# CITY OF ALBUQUERQUE

December 4, 2015

**Re: AIS Retail  
12<sup>th</sup> St & Indian School/Menaul  
Request for 30 Temporary C.O. - Accepted  
Engineer's Stamp dated: 7-8-15 (H13D106)  
Certification dated: 12-1-15**

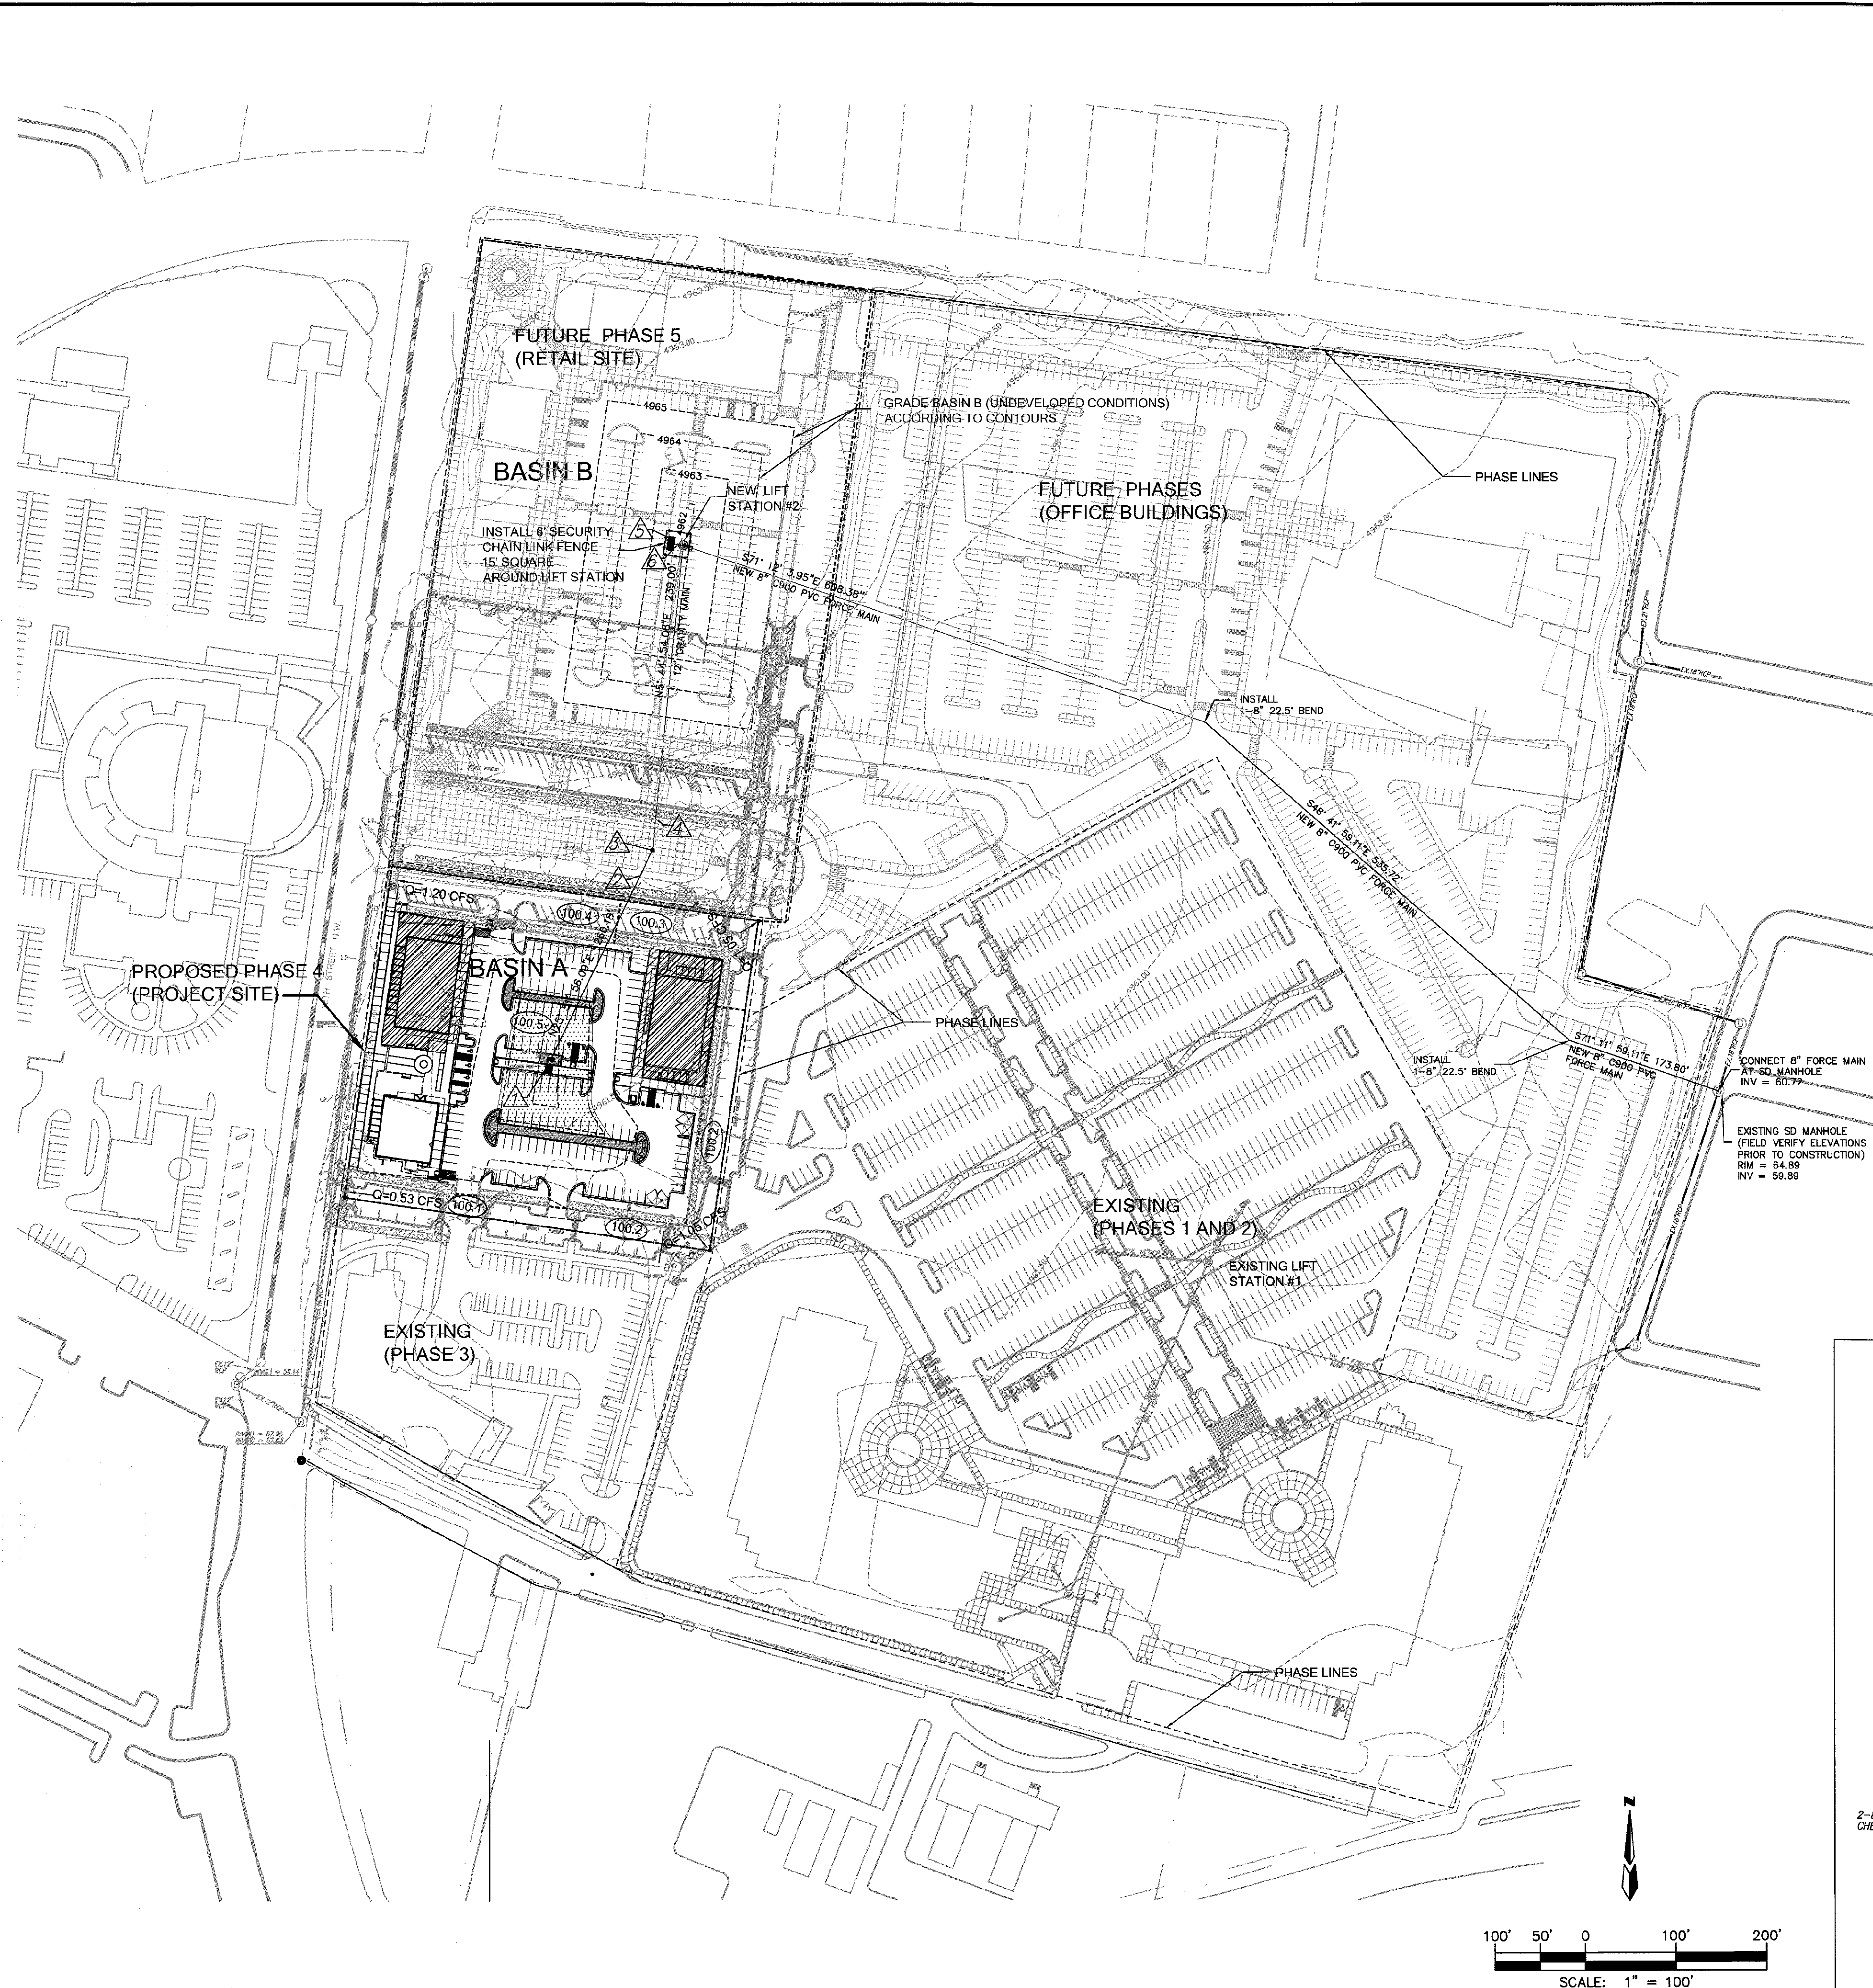
- As-built elevations/spot must be provided.
  - Keyed Note #8 calls for a 3" wide sidewalk culvert. The inside dimension is 2'-2 1/2". Please provide revised calculations indicating this will suffice.
  - Please provide electronic and paper copy of sheet C1B of 4 with new submittal.
- An inspection by our office will need to take place after plan is provided.
